**Monday, November 1, 2021**

**Mercer Island  
Permit No. 2108-113**

**MERCER ISLAND  
Response to Second Intake  
Screening**

**Fire Marshal Jeromy Hicks**  
[Jeromy.hicks@mercerisland.gov](mailto:Jeromy.hicks@mercerisland.gov)  
206-275-7966

A0

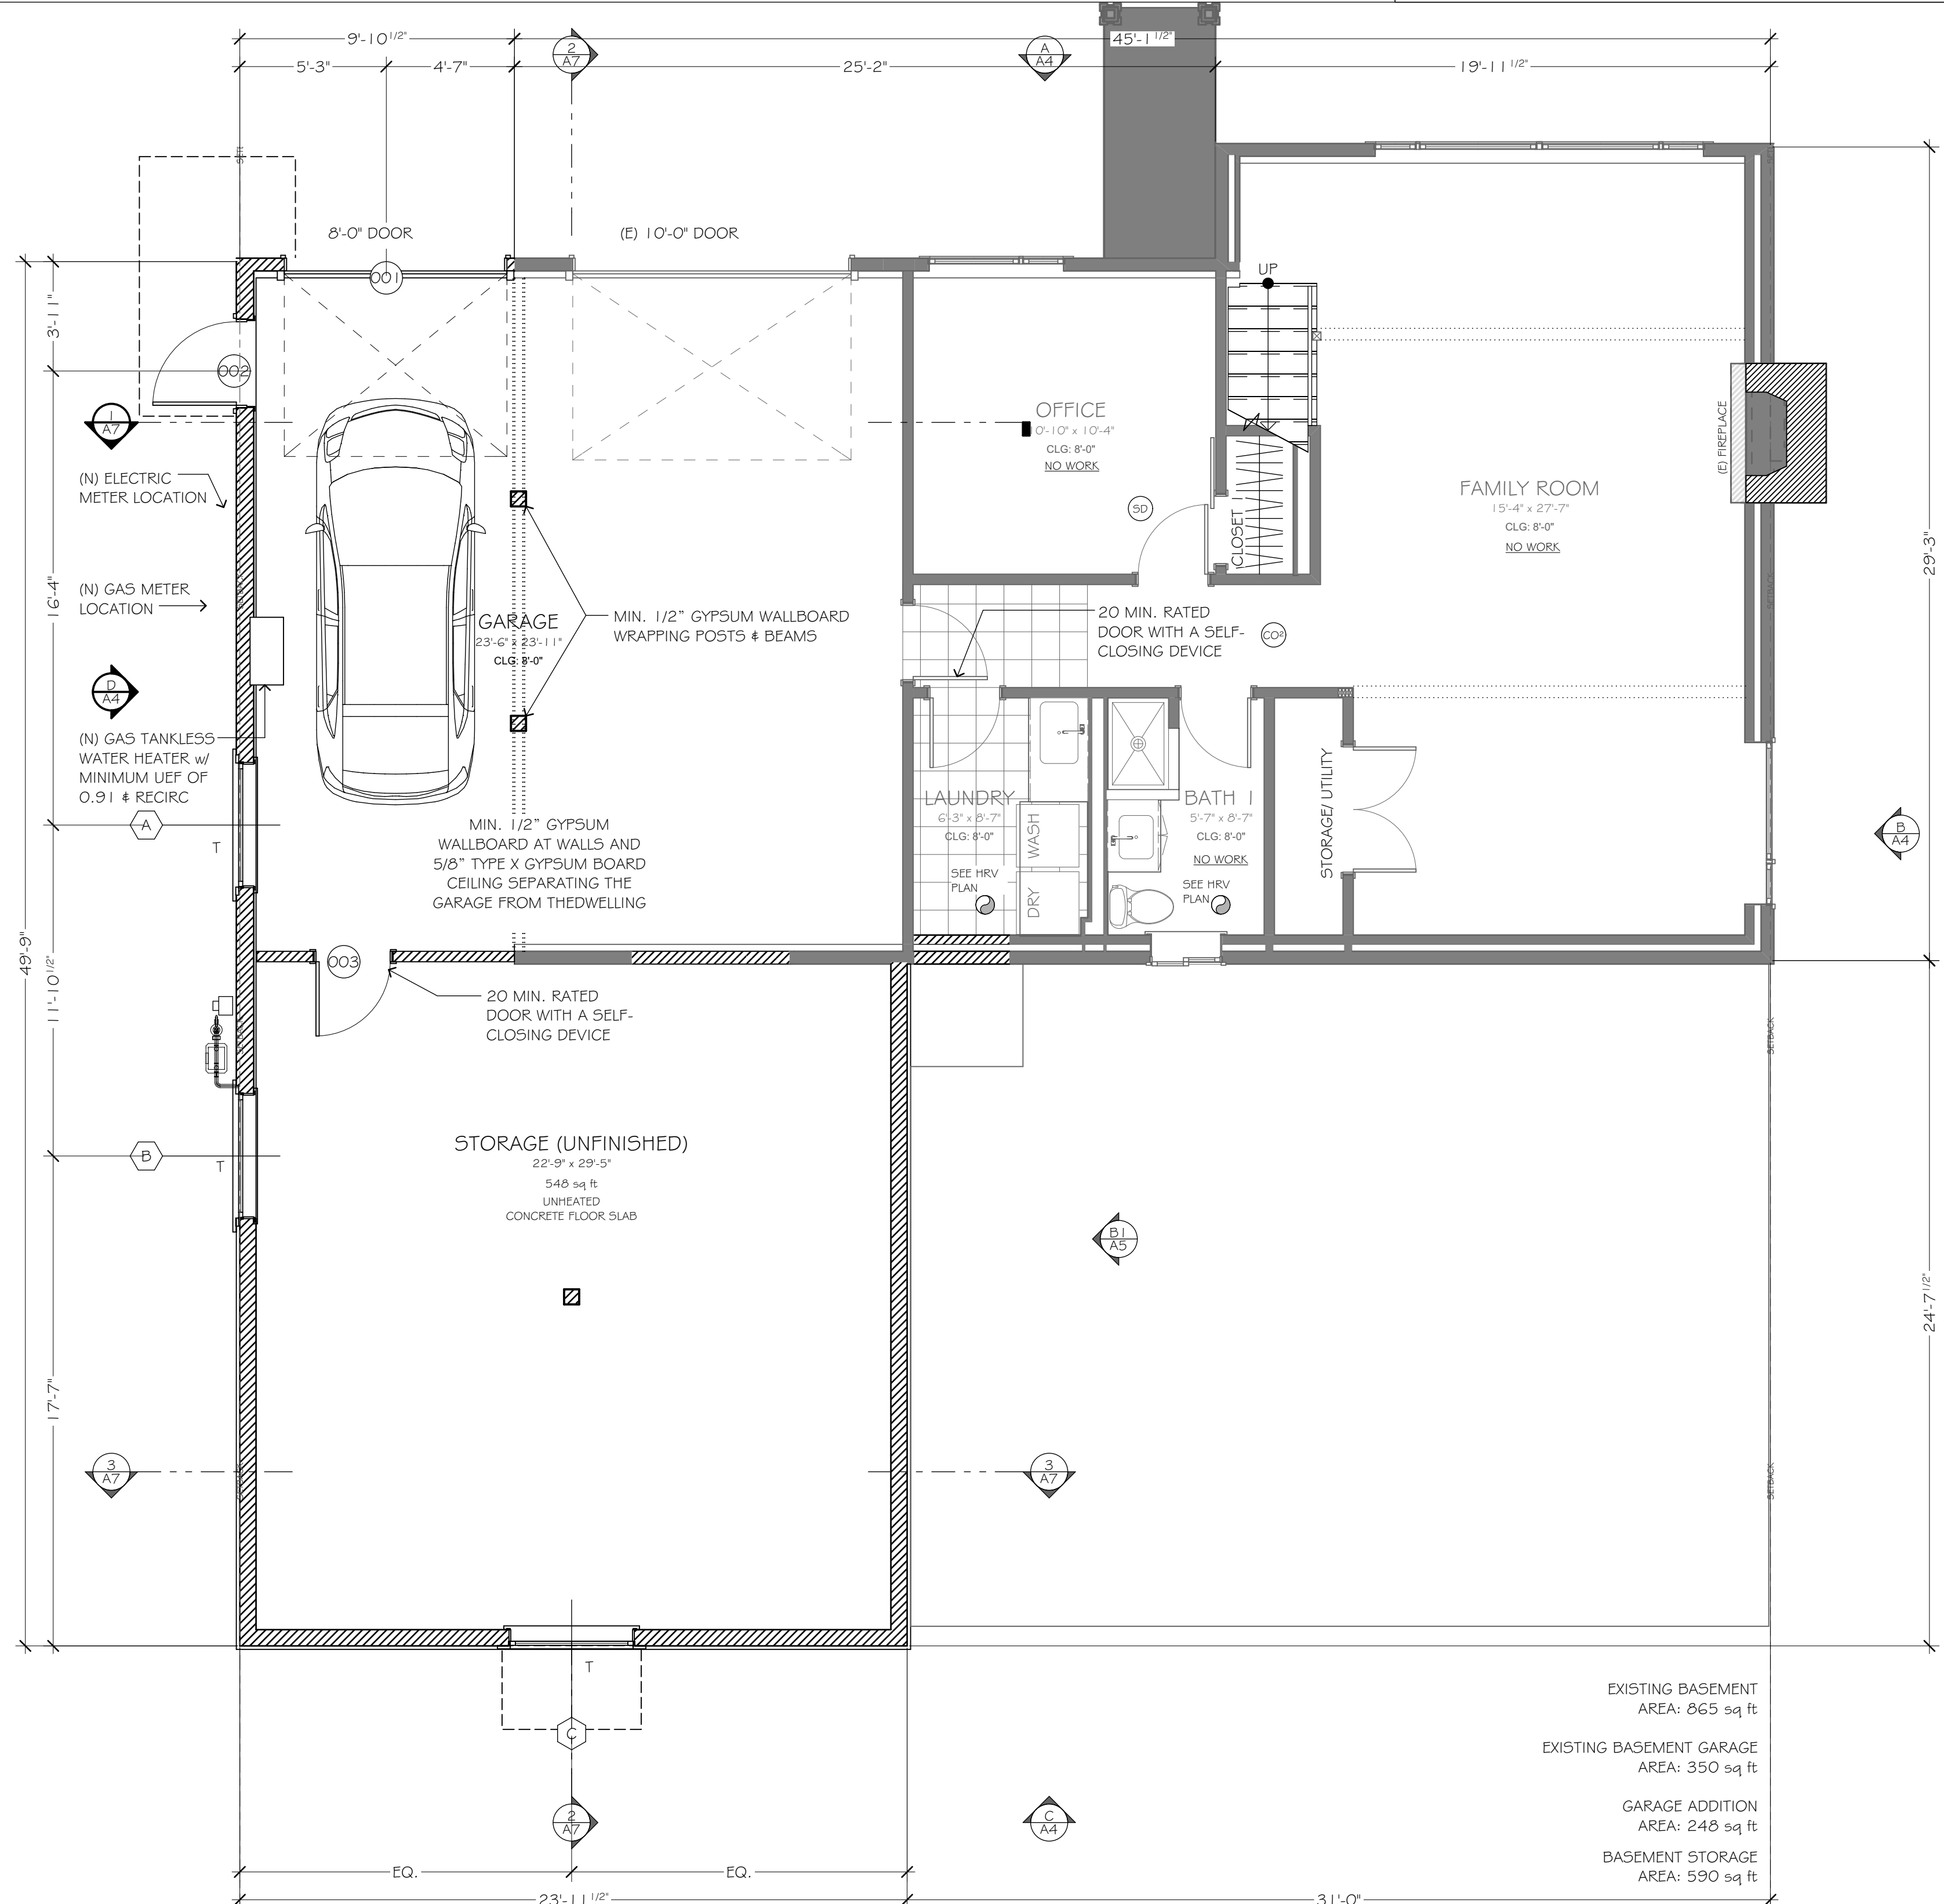
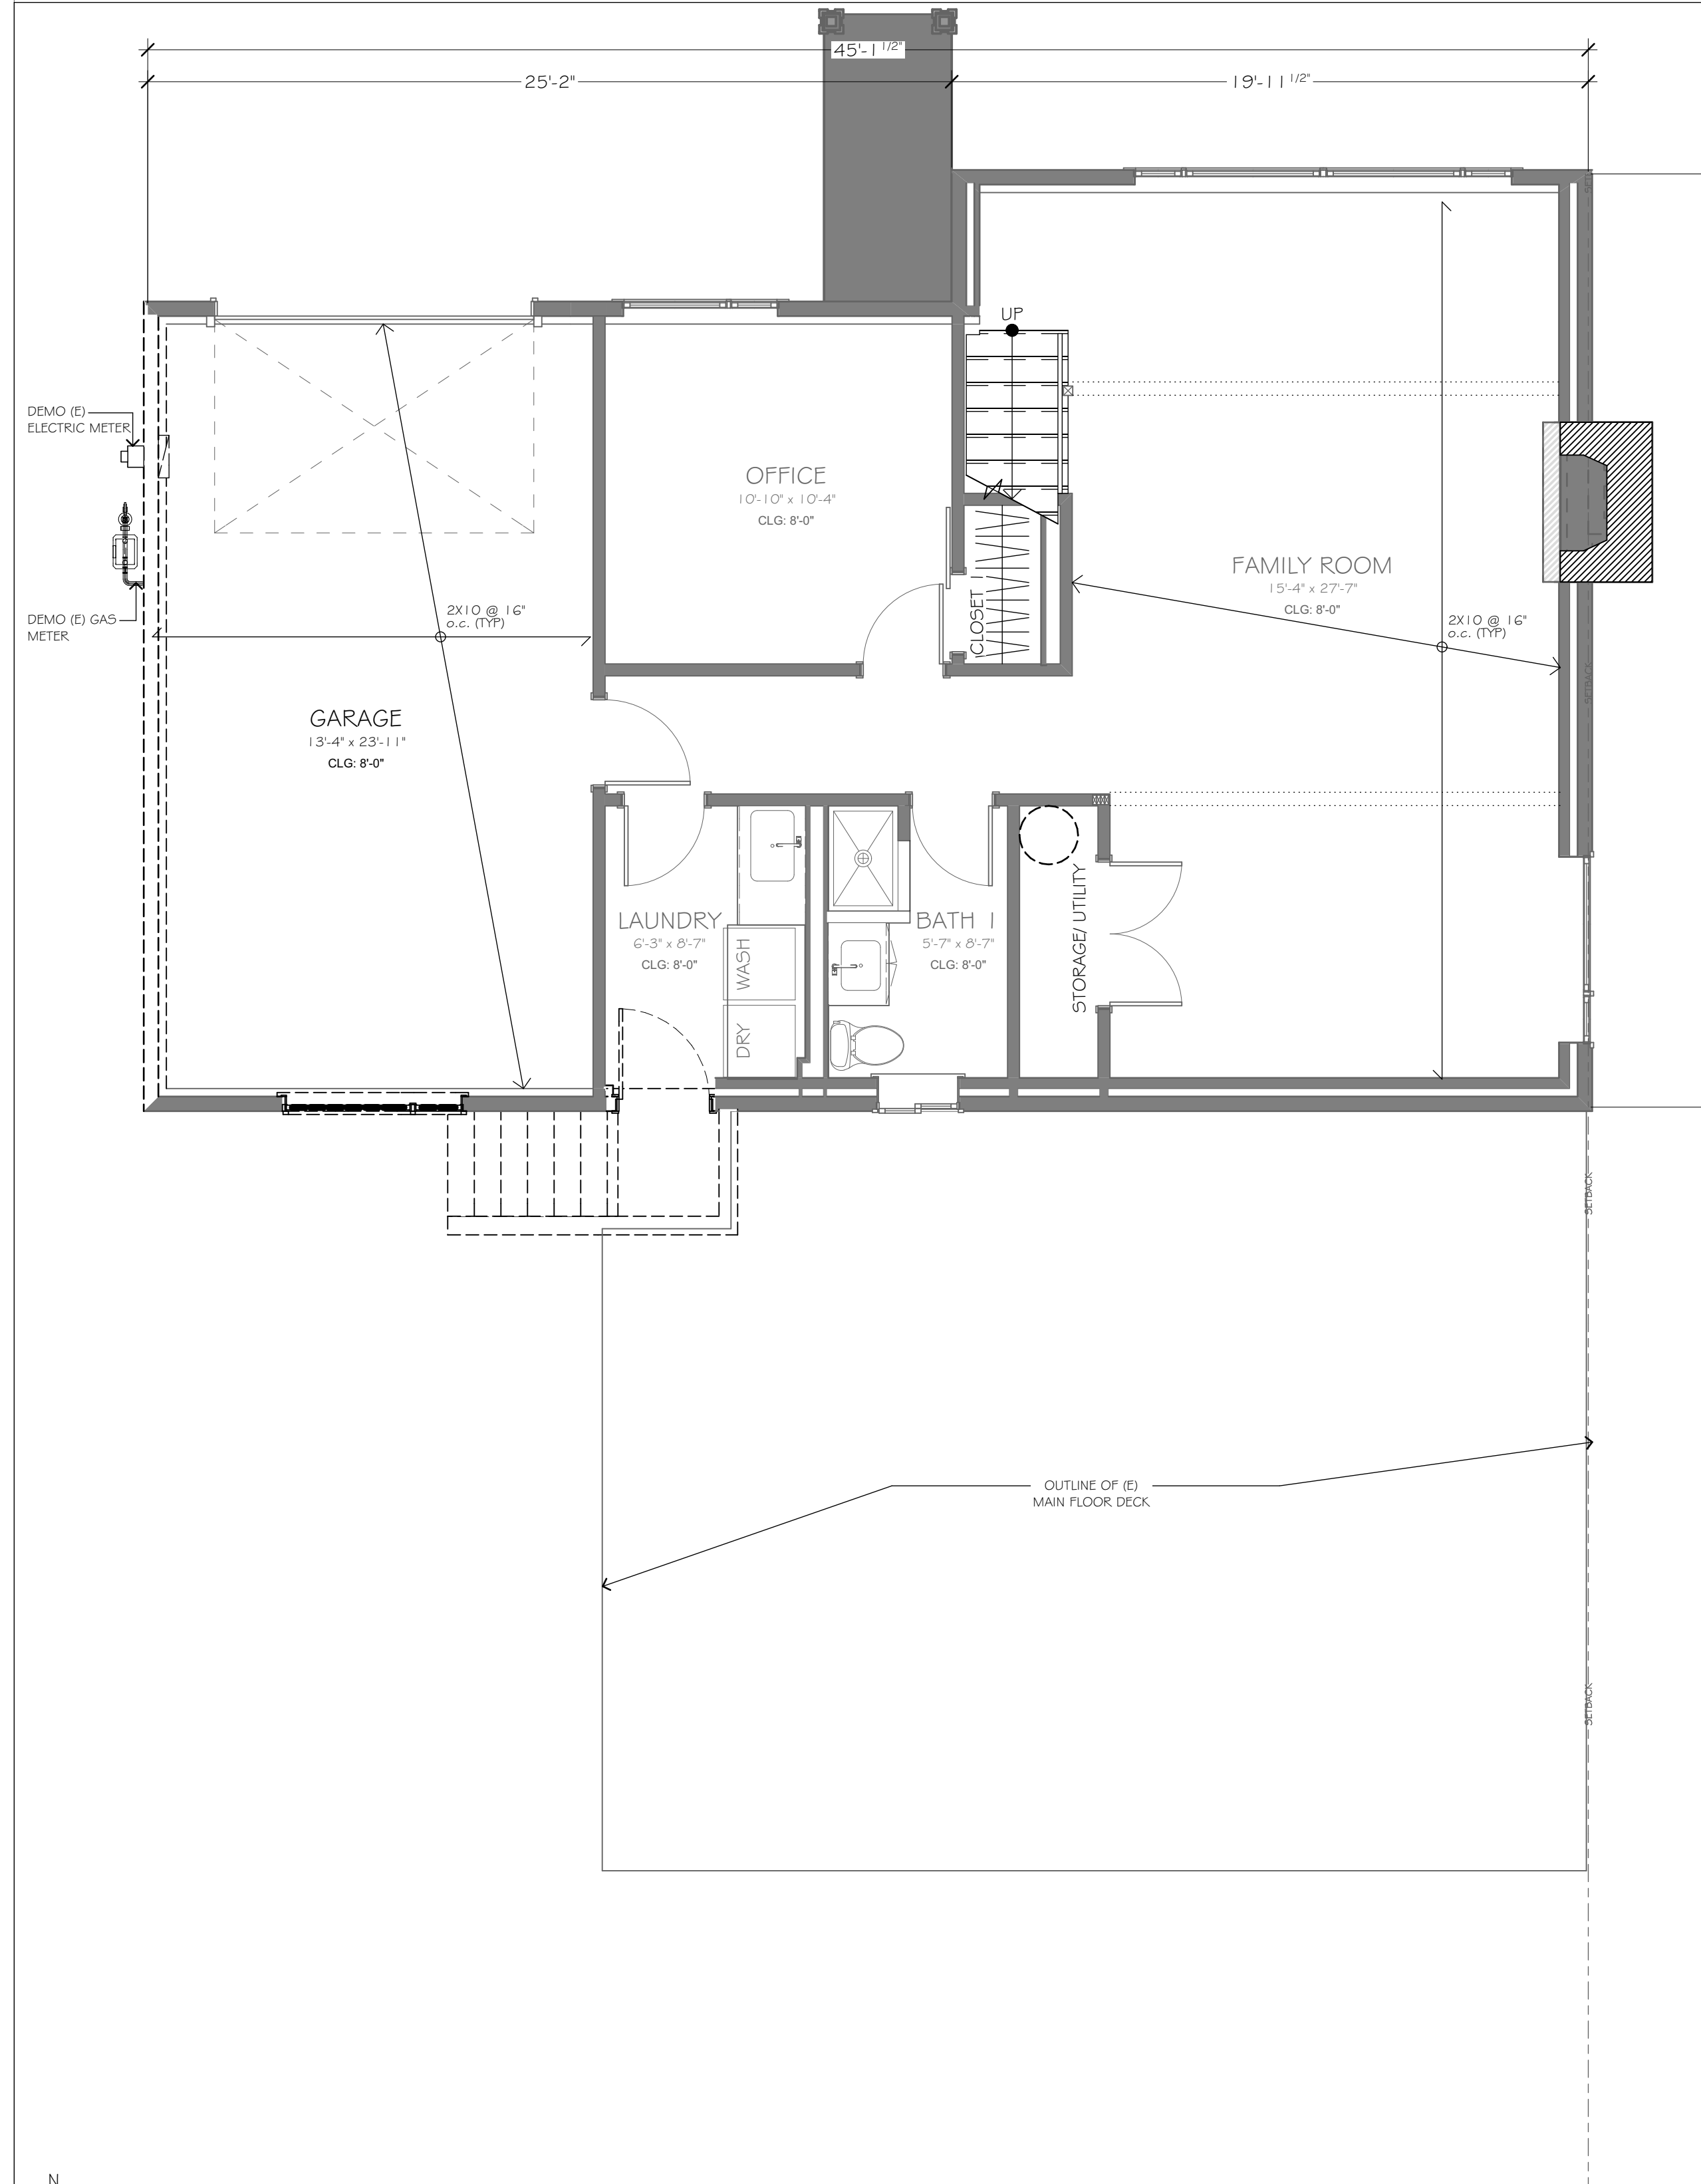
**Confirm that 13d will be installed. This will require a separate permit and may be deferred. Please indicate this on the plan set.**

**Smoke detectors and/or sounders must activate upon waterflow of the fire sprinkler system. Please indicate this on the plan set.**

*RESPONSE: Fire sprinkler system notes added to sheet A1, A2.*

*RESPONSE: Fire sprinkler system notes added to sheet A1, A2.*
